Subject: RE: Request for further information BE/149/20/PL

SITE PLAN

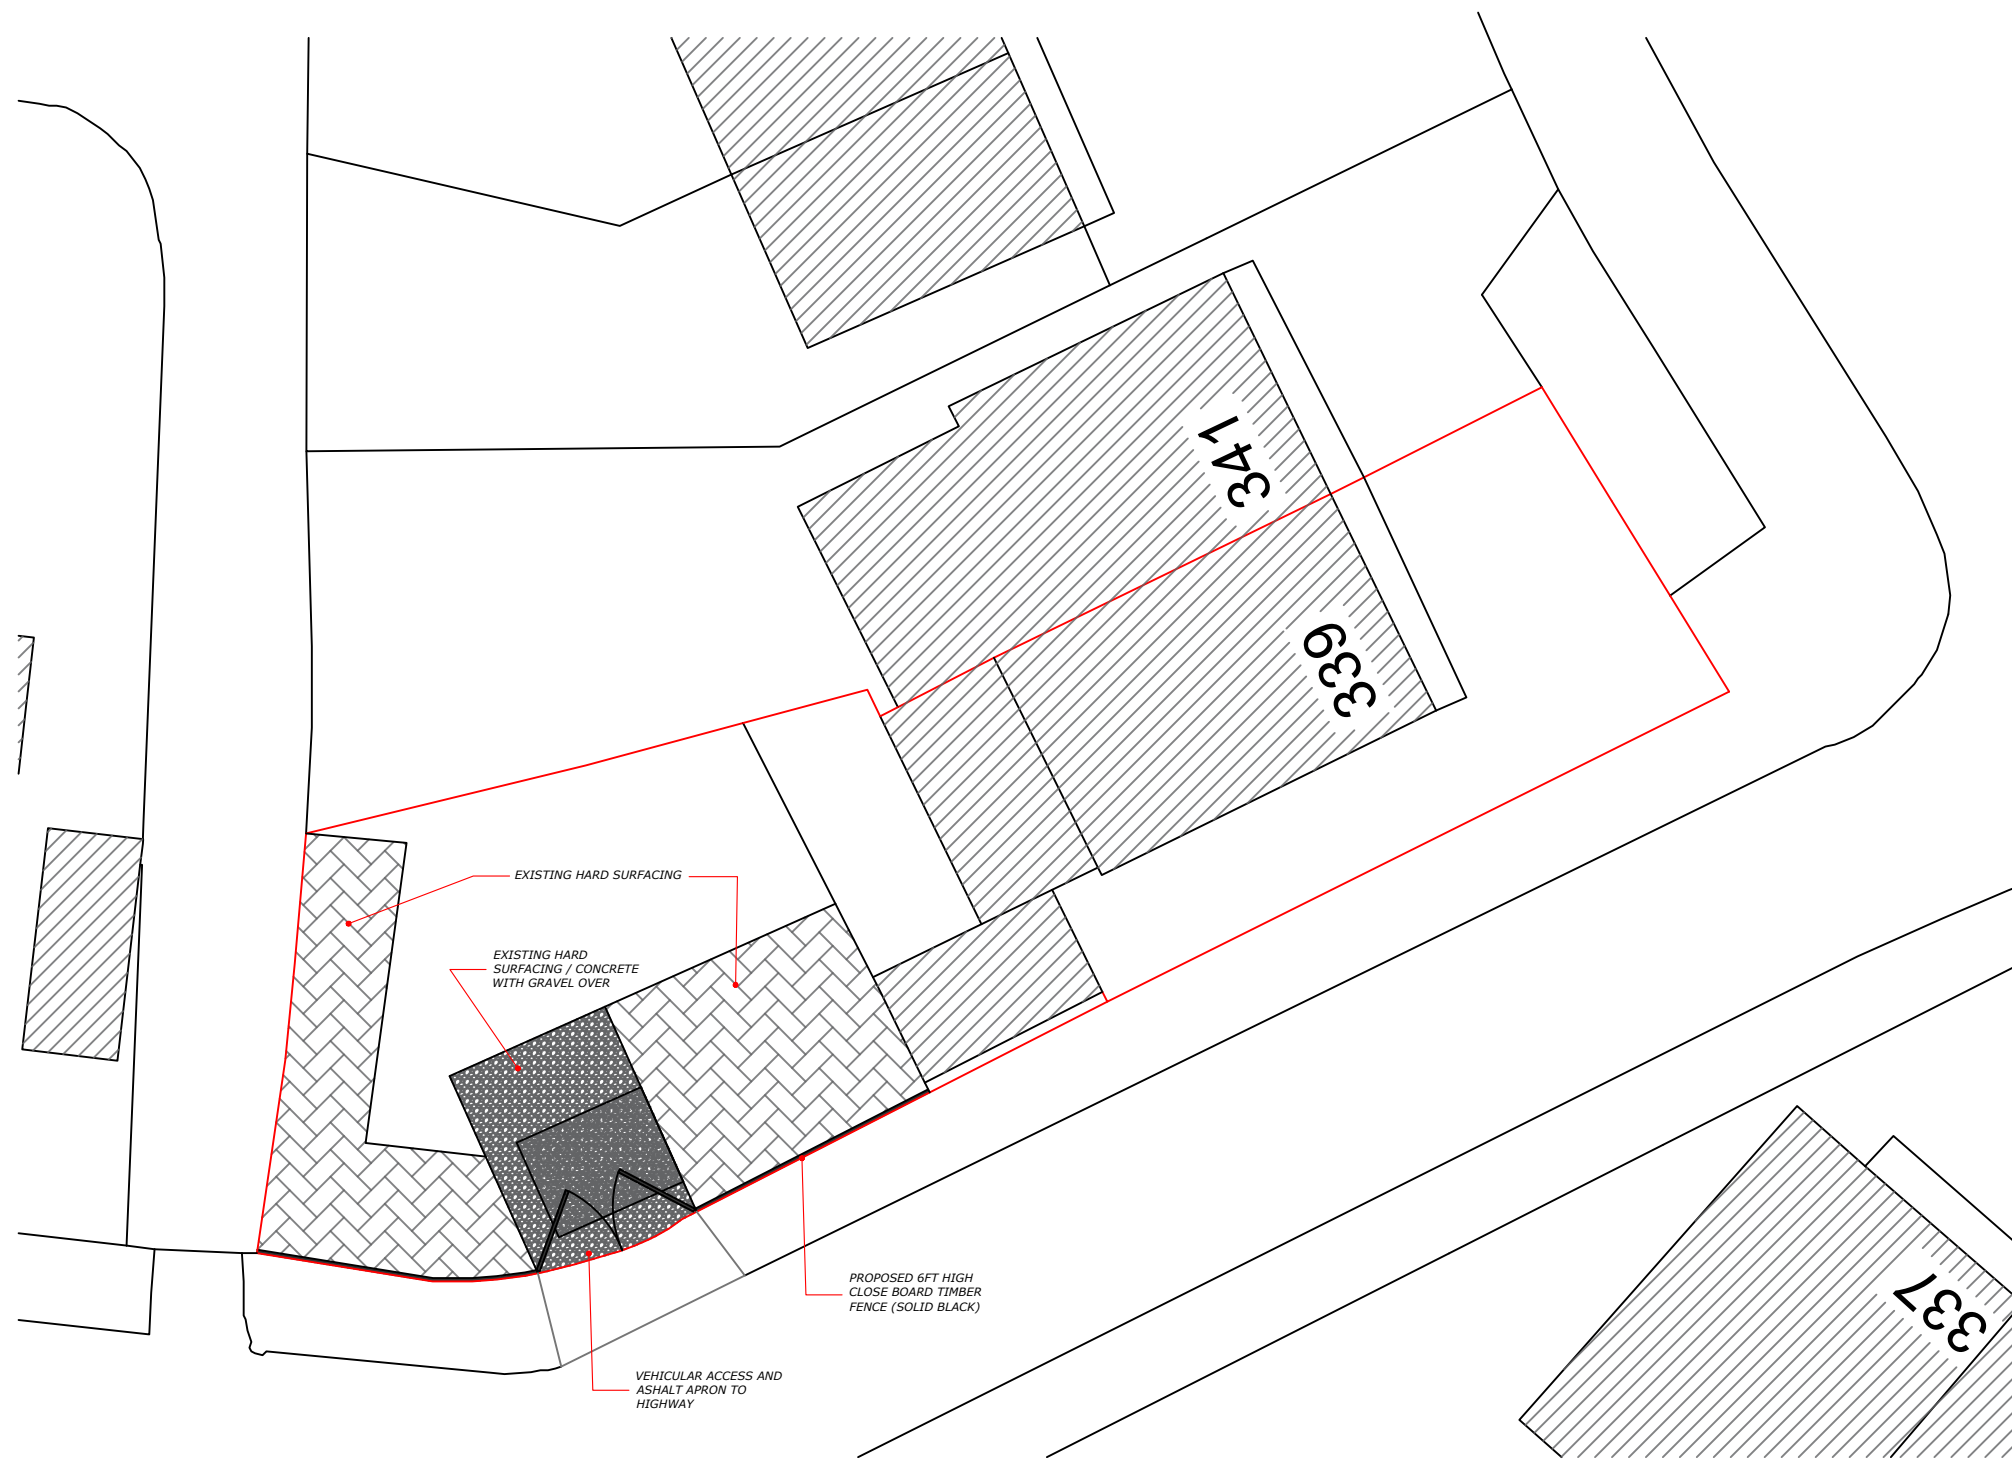
Please provide an elevation, to scale, or a photo of the proposed fence (to include measurements, in metric).

Block Plan

Please clearly highlight the position of the proposed fence.

Please find a revised Block plan attached indicating the location of the fence.
